HINCKLEY NATIONAL RAIL FREIGHT INTERCHANGE

ES Appendix 10.3 Hinckley Consultation Response - BDC

Consultation Response – Blaby District Council - Noise

This response relates specifically to the comments detailed in the '*National Infrastructure Project Section 42 Planning Act 2008 Response*' dated April 2022. The headings and points are reproduced below, shown in blue, and BWB's response is shown in grey.

**ASTON FIRS SECTIONS**

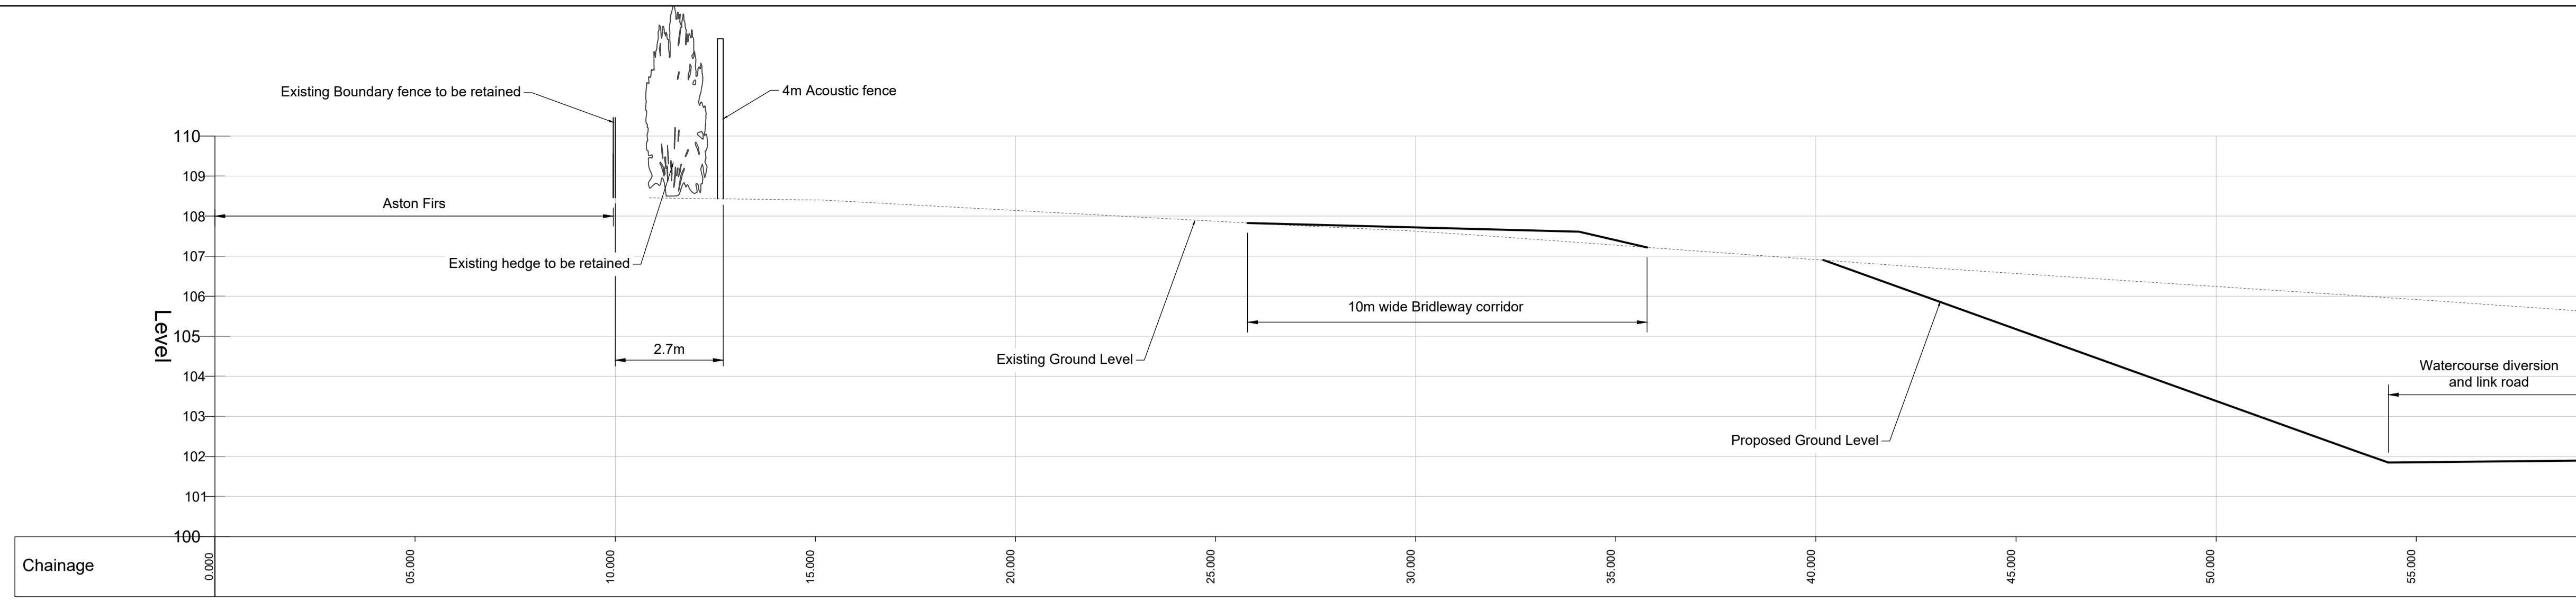
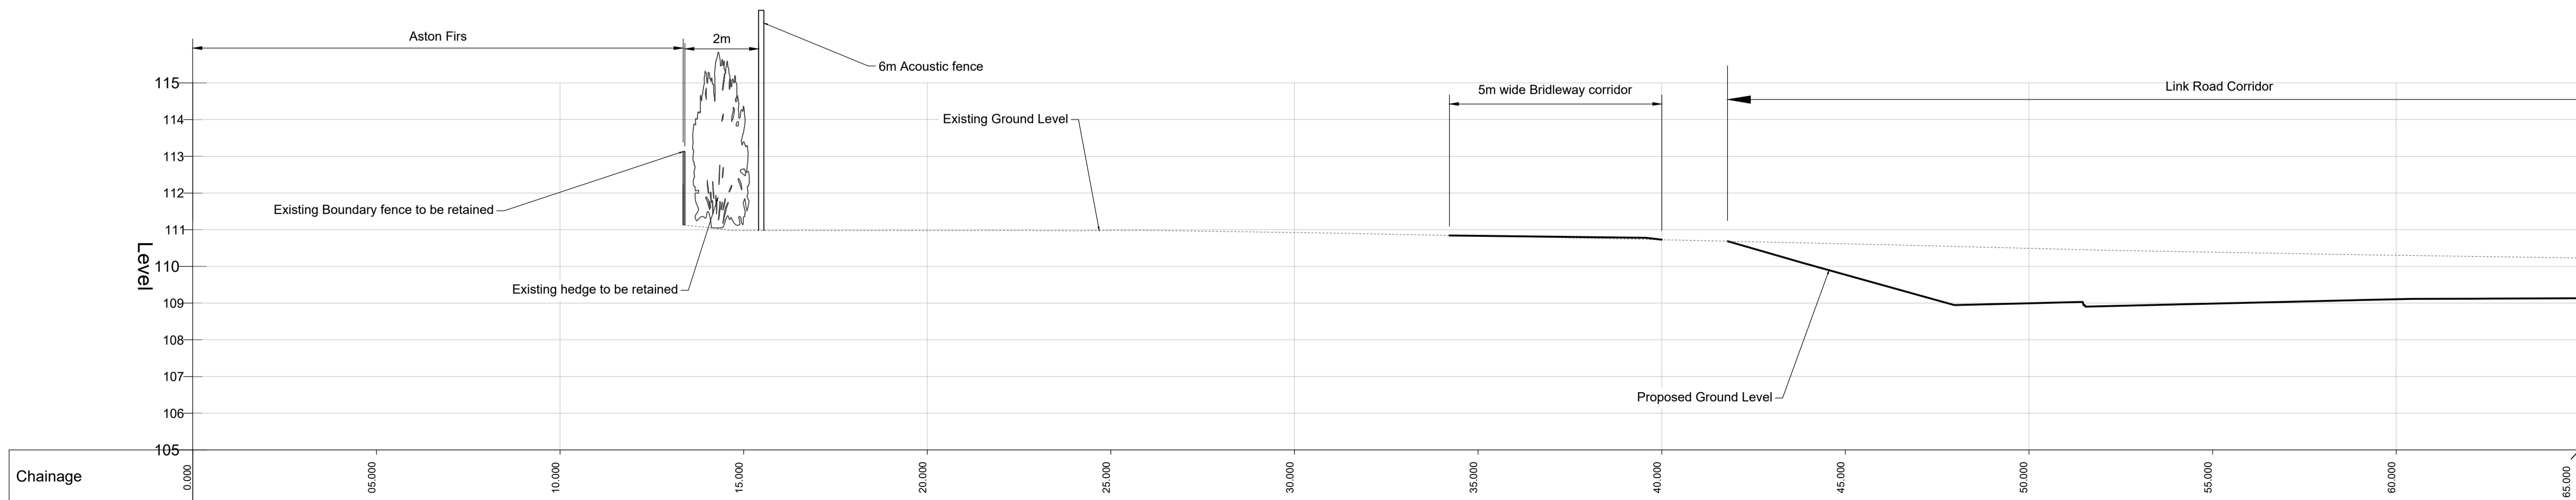
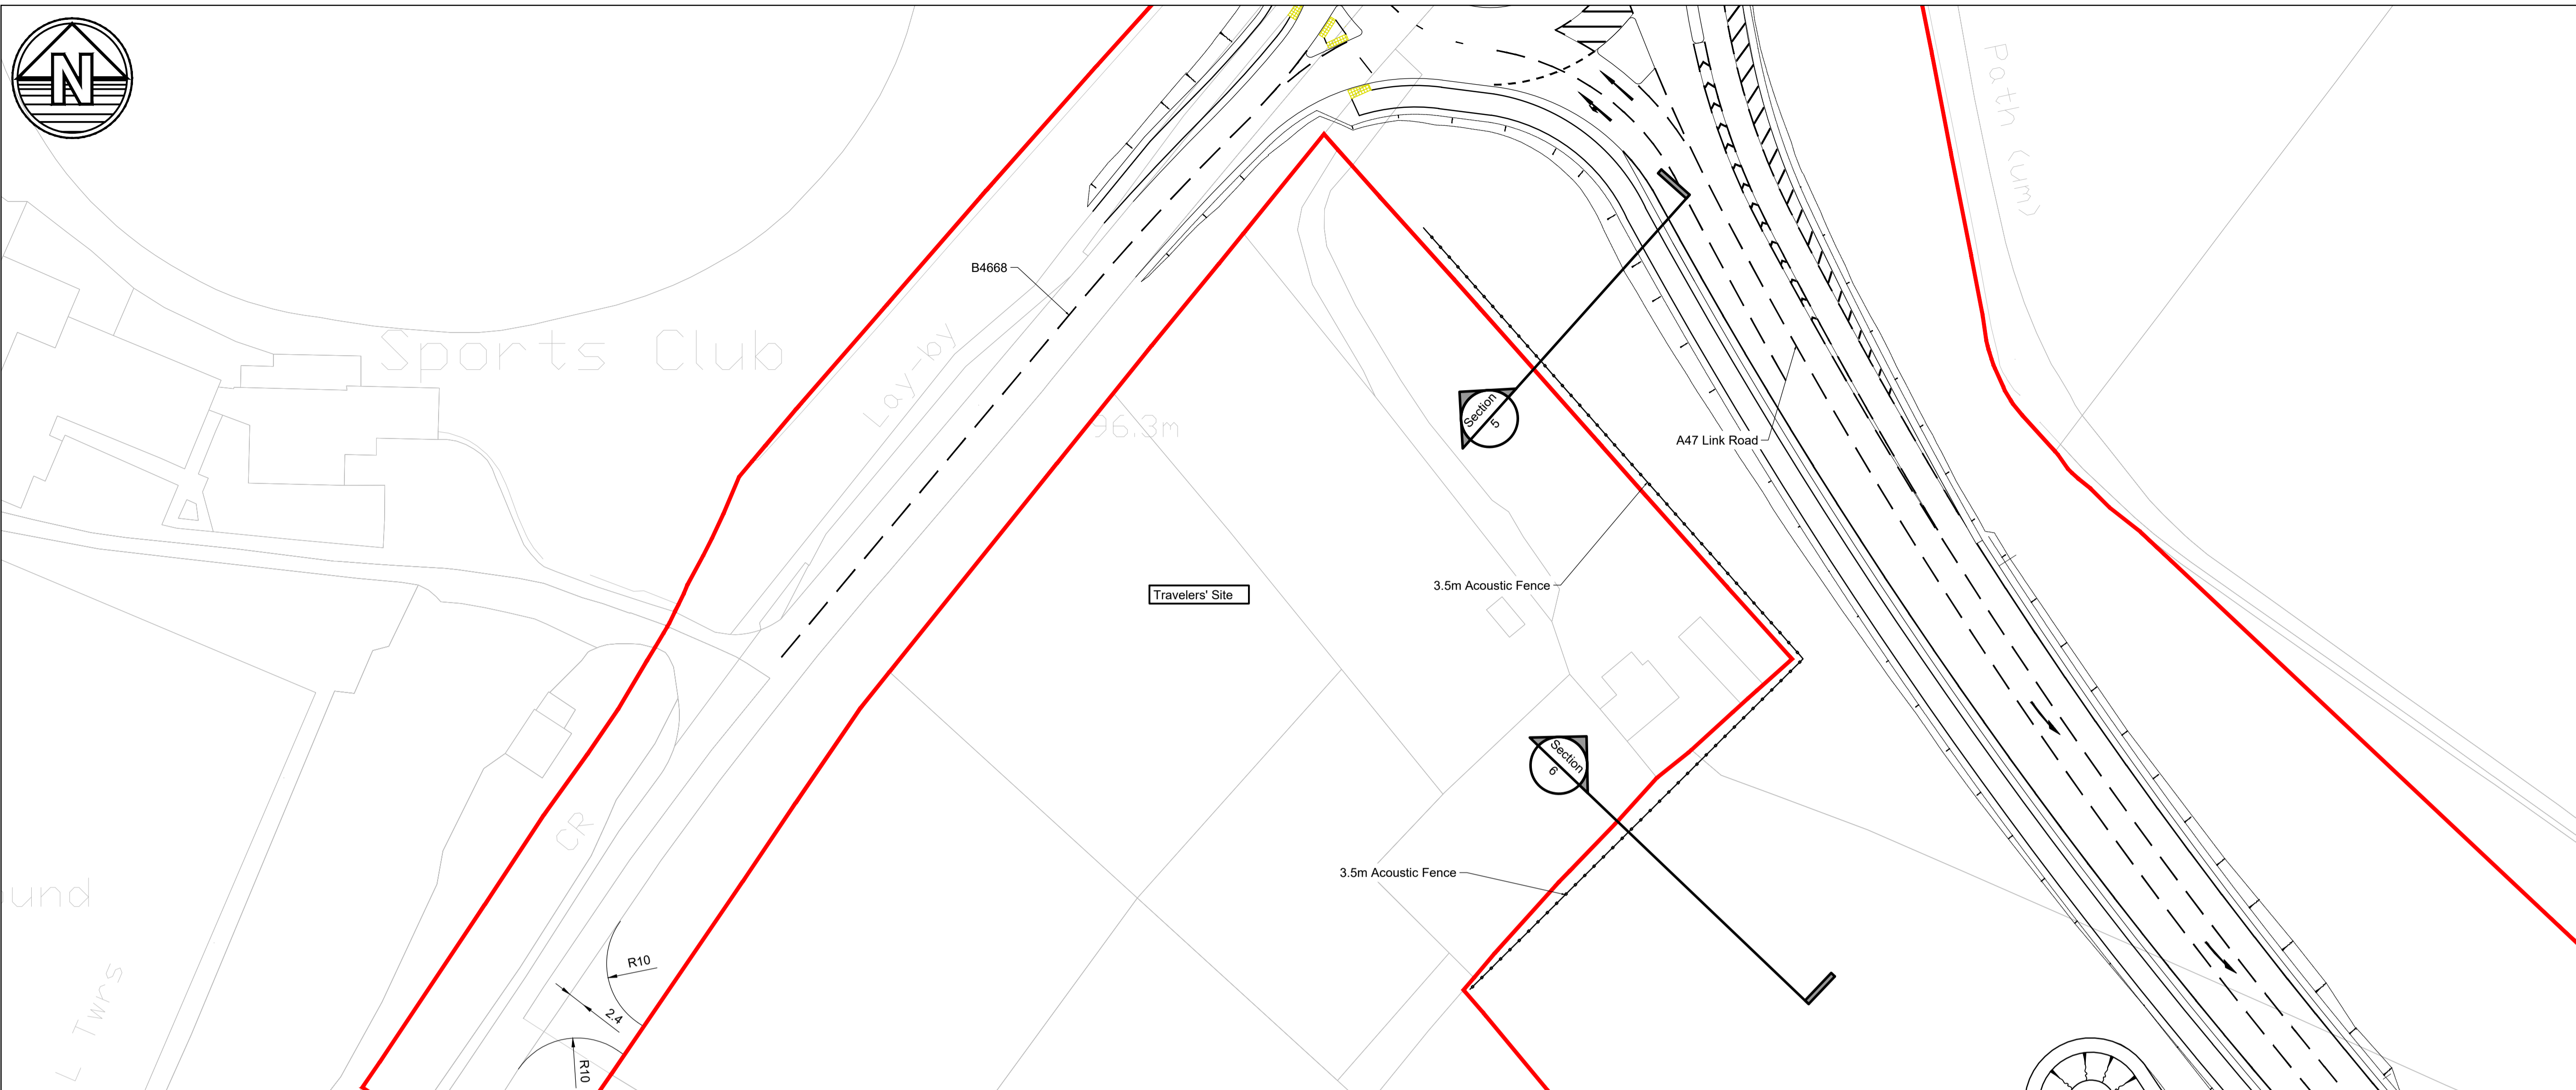
Reflecting the above assumption that it is not the edge of Burbage Common and Aston Firs that has been assessed, it is considered that the levels stated are an under representation. For Aston Firs, it is cited in Table 10.49 as being 10 dB lower than the very close-by NSR15 figures (51 compared to 61 dB), despite the wood actually projecting closer to the A47 link road. This suggests that Aston Firs would then exceed the 55 dB recommended limit and thus generate an unacceptable relationship.

As discussed above, noise contours will be produced for the final ES, demonstrating the noise propagation across the site.
